MODIFICATION REQUEST:

**92, Manning Street, Tuncurry.
7 storey Commercial/retail building Lot 1 DP
301489. MP08_0042 (Mod.2).**

Director-General's
Environmental Assessment Report
Section 75W of the
Environmental Planning and Assessment Act 1979

March 2012

DRAWING TITLE:
Level 05-06

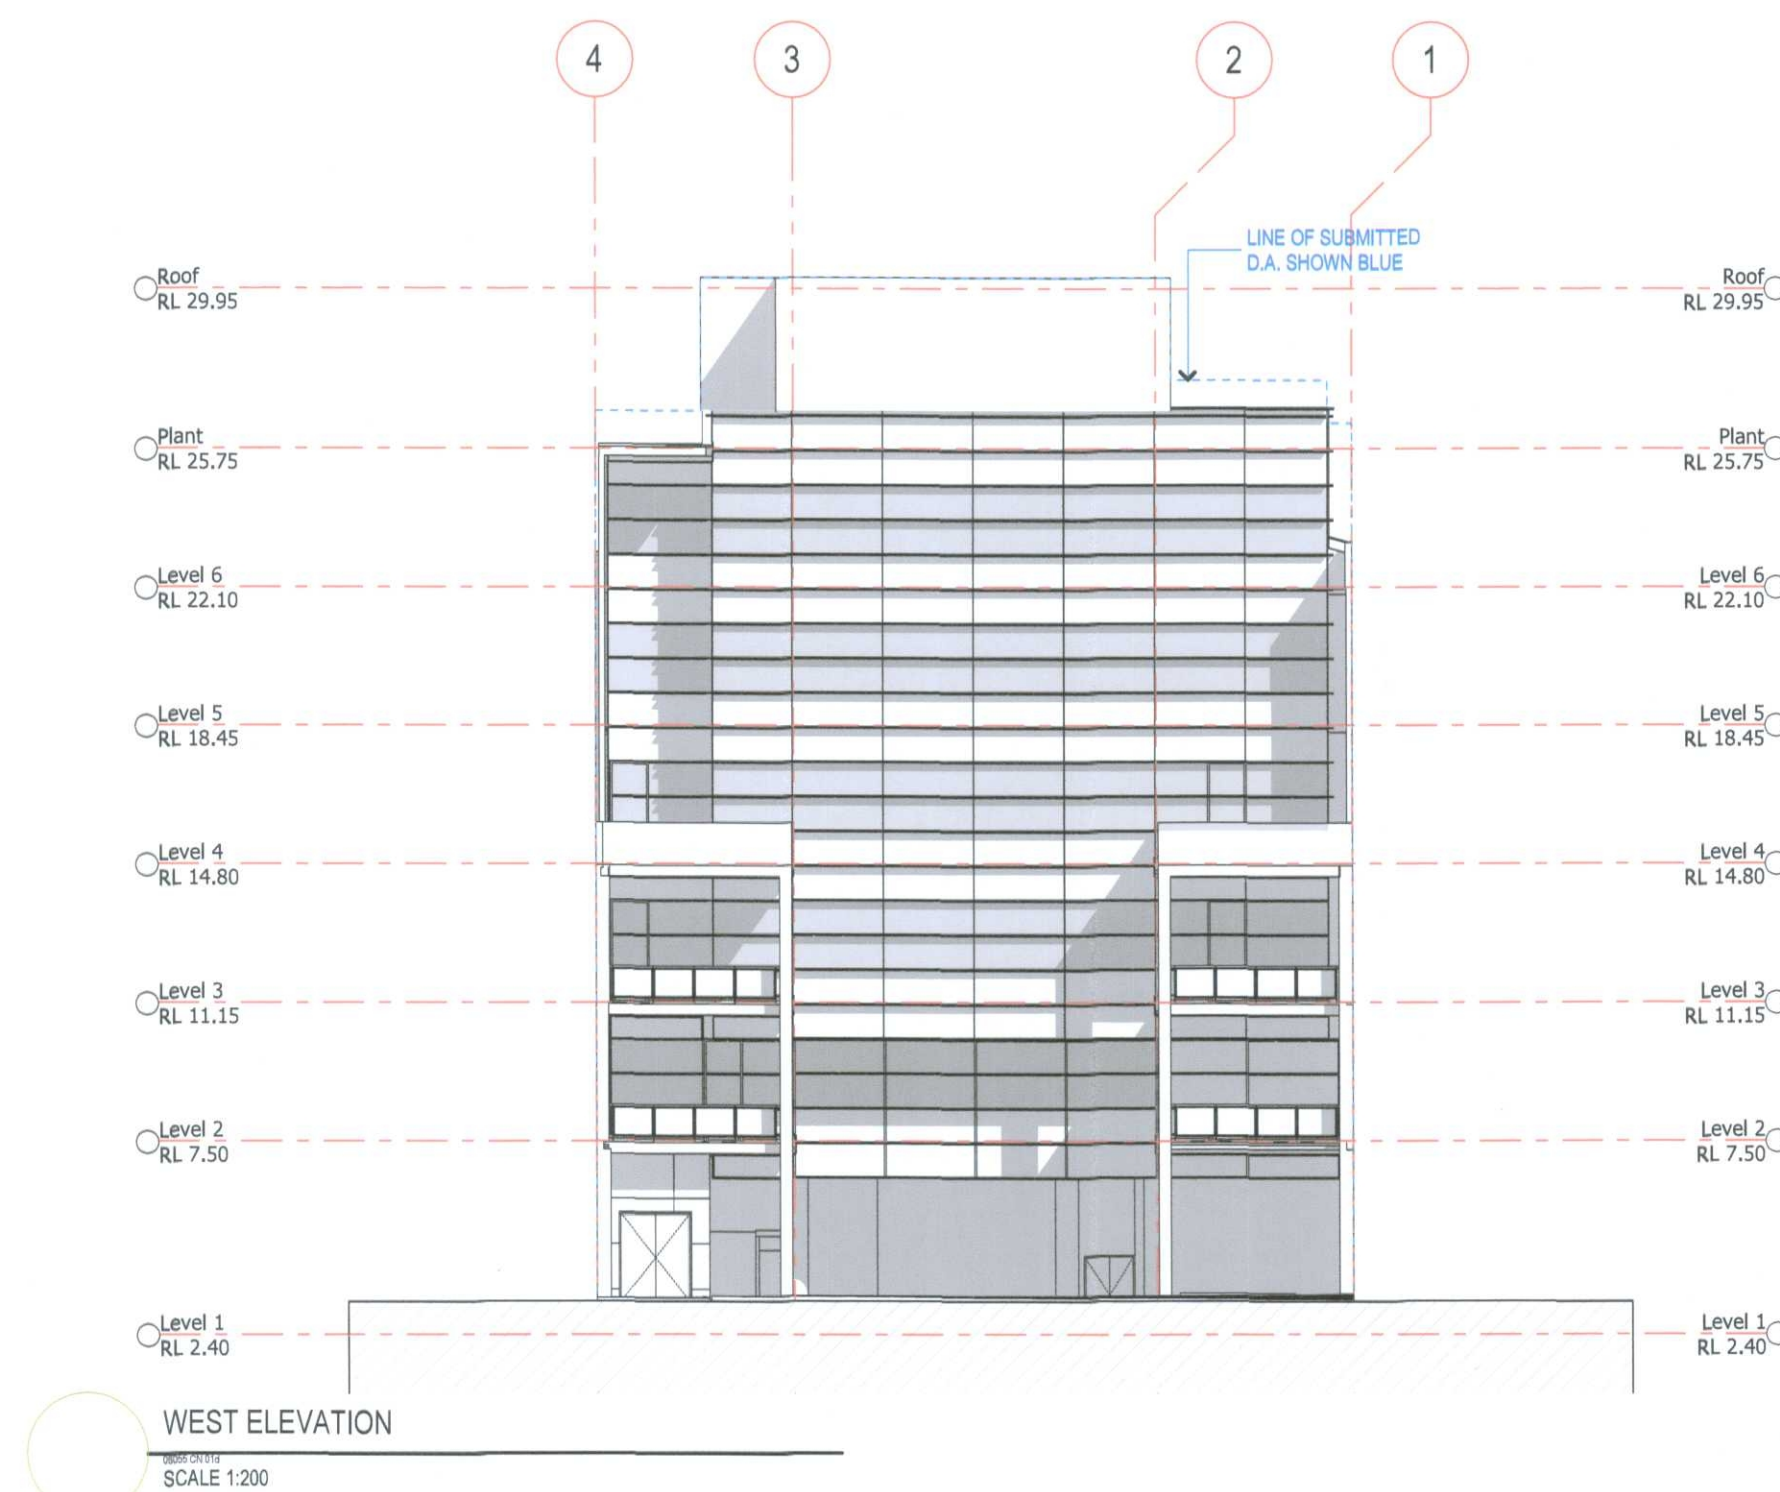
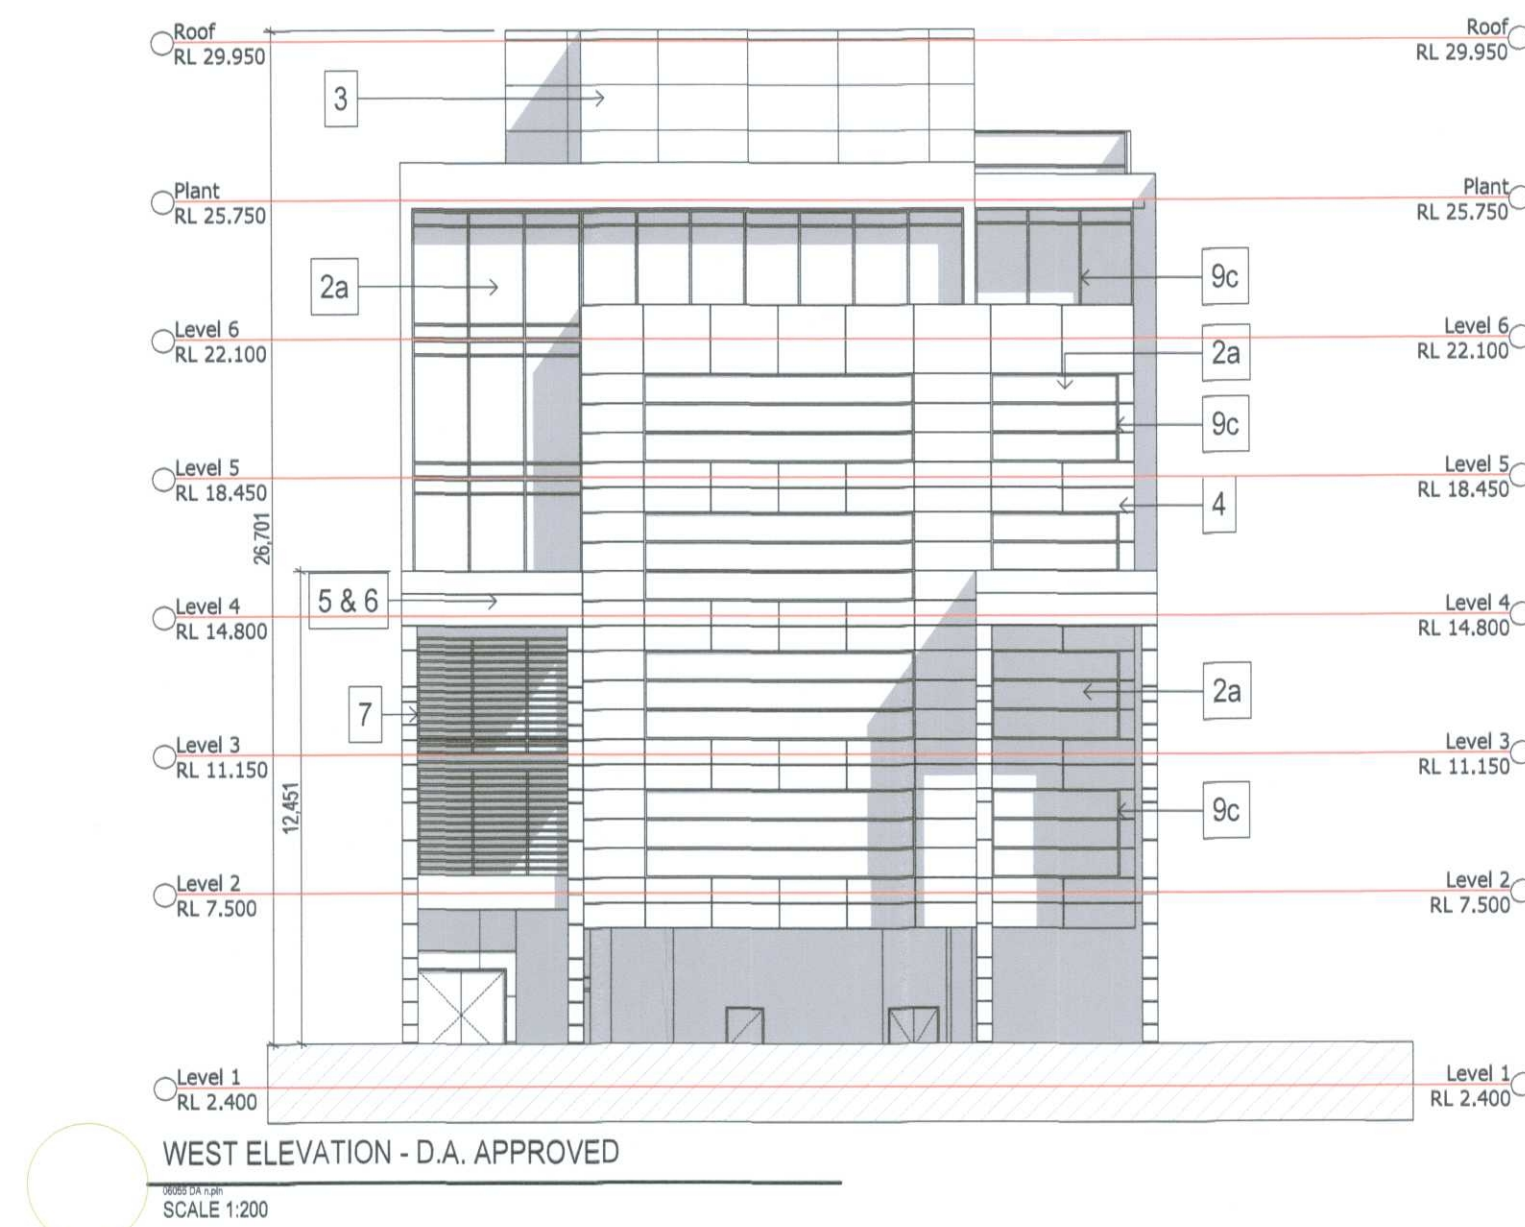
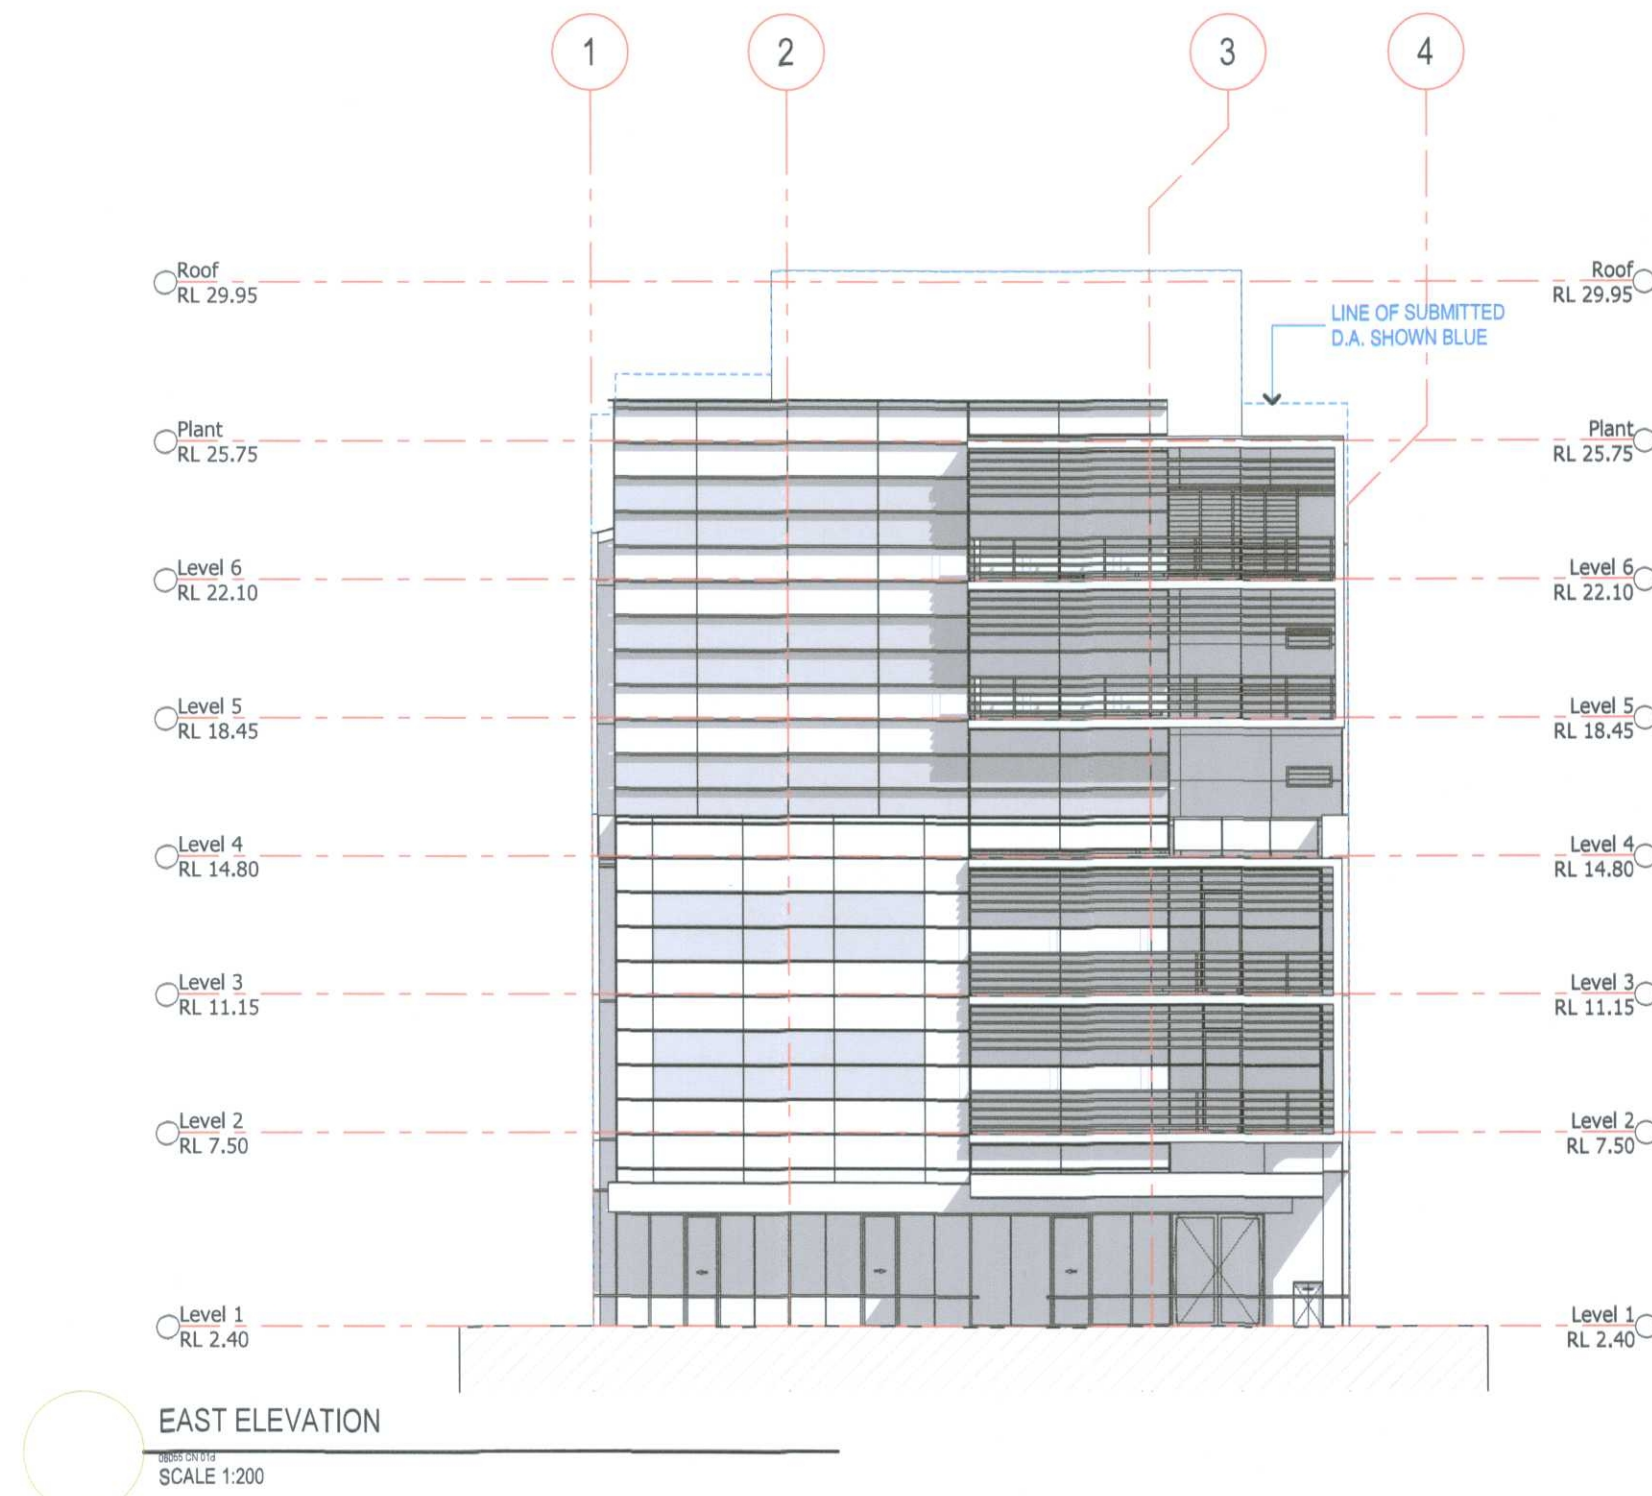
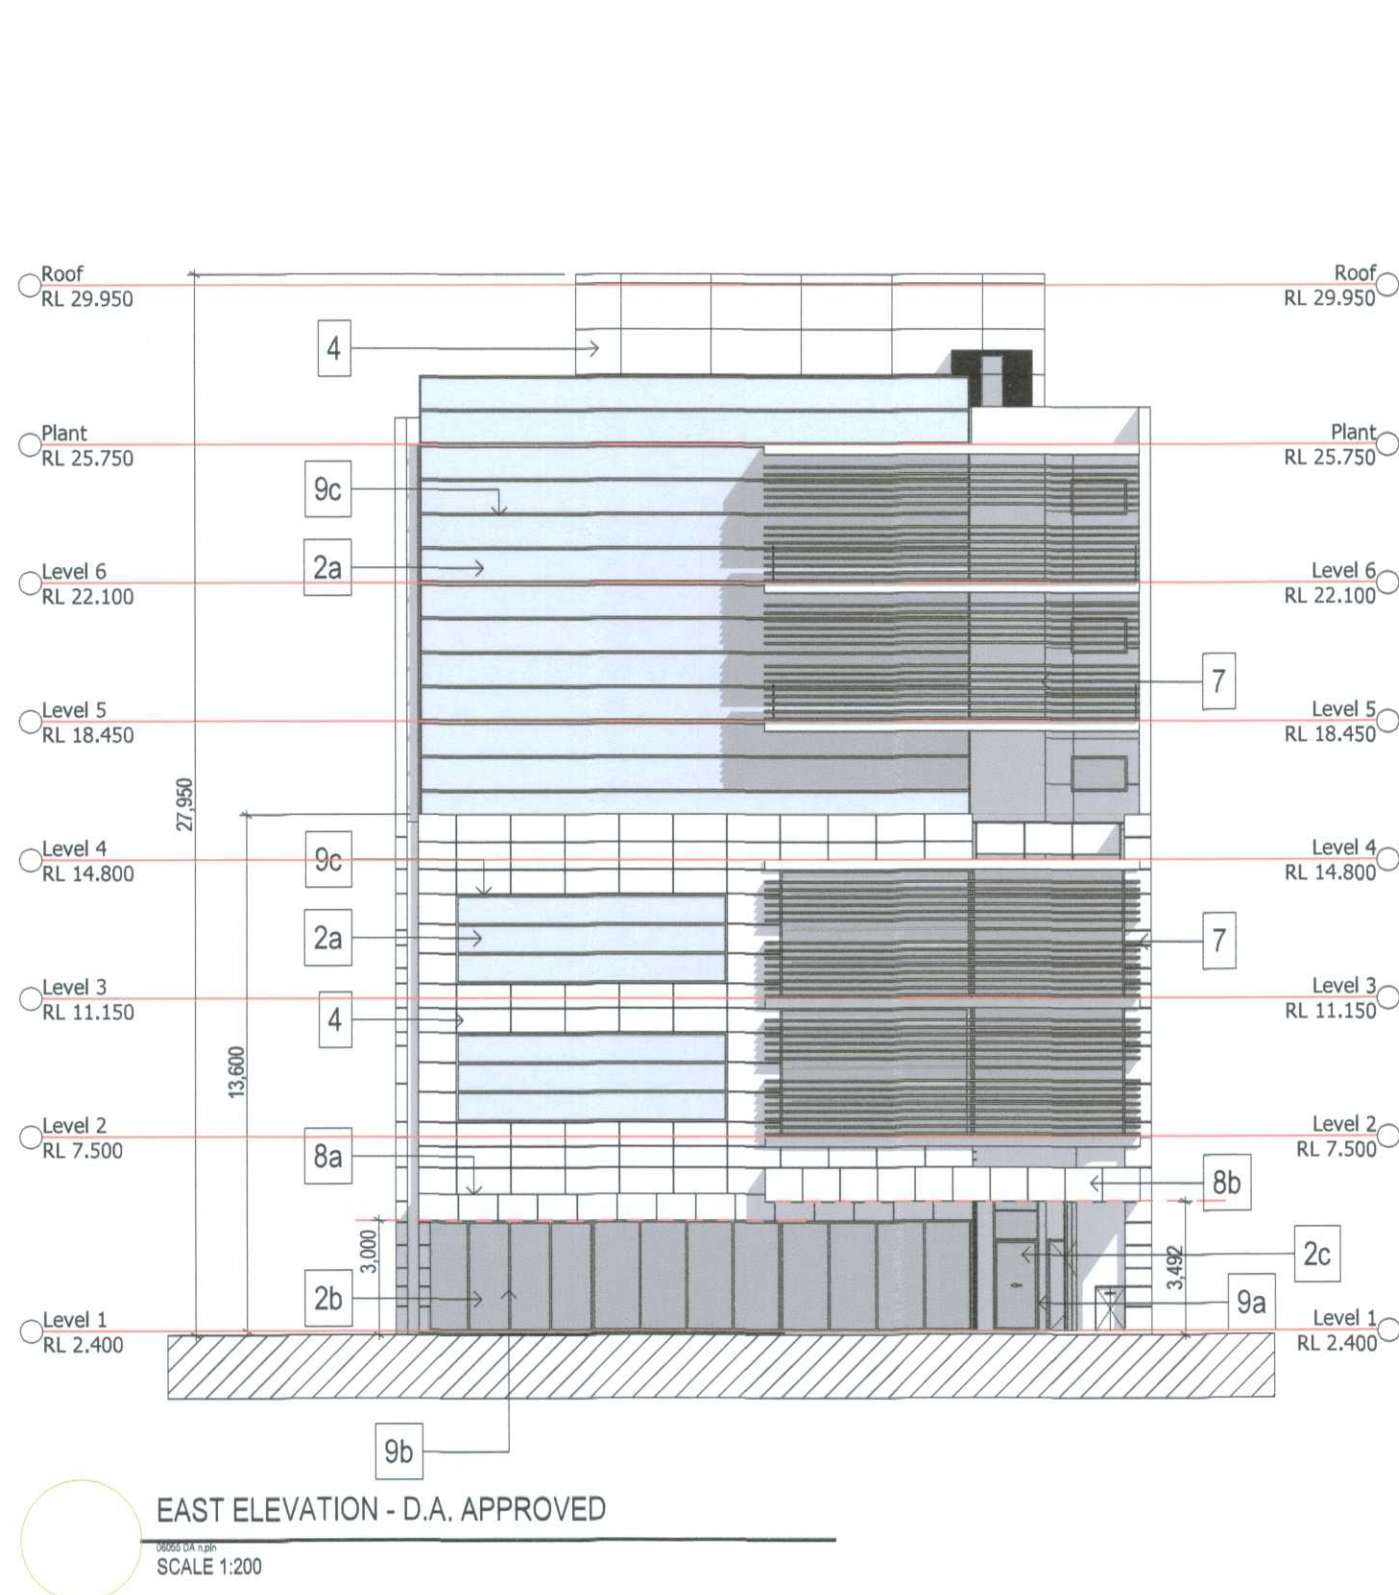
Great Lakes Council by response dated 6 January 2012 advised that the plant room was undefined in the modification plans and that new windows near the side boundary on level 6 require possible contingency treatment to maintain future privacy and neighbouring site redevelopment equity. These issues have subsequently been resolved by the submission of the plant room plans and the imposition of new condition F23 (see Table 2 below) which satisfy council's concerns.

Issue	Consideration
<p>1. New windows are proposed near the side boundary on level 6 (item f, Table 1).</p> <p>This requires a contingency to allow for their treatment to maintain future privacy and neighbouring site redevelopment equity.</p> <p>Planning Control: DCP51 setback requirements (Clause 15.7, Table 15.1):</p> <p><i>9 metres where a habitable room/balcony faces a habitable room/balcony on an adjacent property</i></p> <p><i>6.5 metres between habitable rooms/balconies and non habitable rooms/balconies on an adjacent property</i></p> <p><i>4.5 metres where a non-habitable room/blank wall faces a non habitable room/blank wall on an adjacent property</i></p>	<p>Generally, the setback controls specified in Table 15.1 of DCP 51 would require a side wall incorporating windows to be setback up to 9 metres. The approved southern blank wall on level 6 was setback 0.725 metres by virtue of condition B1, essentially to improve the urban design of the upper levels of the building.</p> <p>The DCP height controls allow construction of a building of similar or even greater height, on neighbouring sites in the future. Therefore it is necessary to consider the implications of future development potential of neighbouring sites. Note that in DCP 51, sites having width less than 30 metres are restricted to 4 storeys.</p> <p>Setbacks are also normally required in order to preserve future privacy because a presumption exists that a future redevelopment may incorporate a residential use with windows facing the proposed windows. The setback controls are also aimed at maintaining a level of equity between adjoining sites so that neither is disadvantaged in terms of development potential by allowing the excessive "borrowing" of window amenity from its neighbour. Therefore when windows are placed within the specified side boundary setbacks, the windows must be unrequired (by the BCA, in terms of light and ventilation) and be capable of being treated so that they also allow suitable privacy and amenity objectives to be achieved for any future residential development on the adjoining site</p> <p>The proposed windows are unrequired. Therefore, the proposed side elevation windows will be regarded as a temporary opportunity for occupants to enjoy views from the side of this commercial building. The most appropriate means to control these windows is to provide for a condition to require a covenant to specify that the side boundary windows to be made suitable for, and, if necessary, deferring to, a future development at the time when this occurs on the neighbouring site. The covenant will require the windows to be treated or replaced (if necessary) with chemically or mechanically etched glass so as to eliminate any privacy concern, if needed to mitigate privacy or achieve development density capability, in the redevelopment of the neighbouring site. The accepted method is to provide for a S88(B) covenant in favour of the Council.</p> <p>The Council should regard the covenant as a discretionary tool whereby the Council can enforce its design intent to achieve a reasonable planning outcome for the neighbouring site, if such enforcement is indeed required (given contemporary development controls). The covenant should be maintained for so long as the building which has the covenanted windows continues to exist.</p>

The proposed modifications are acceptable, subject to a new condition F23 for a covenant to require future treatment (privacy etching or frosting) of the windows at level 6. The covenant would only be enforced to maintain future equity and privacy of neighbouring property on its redevelopment.
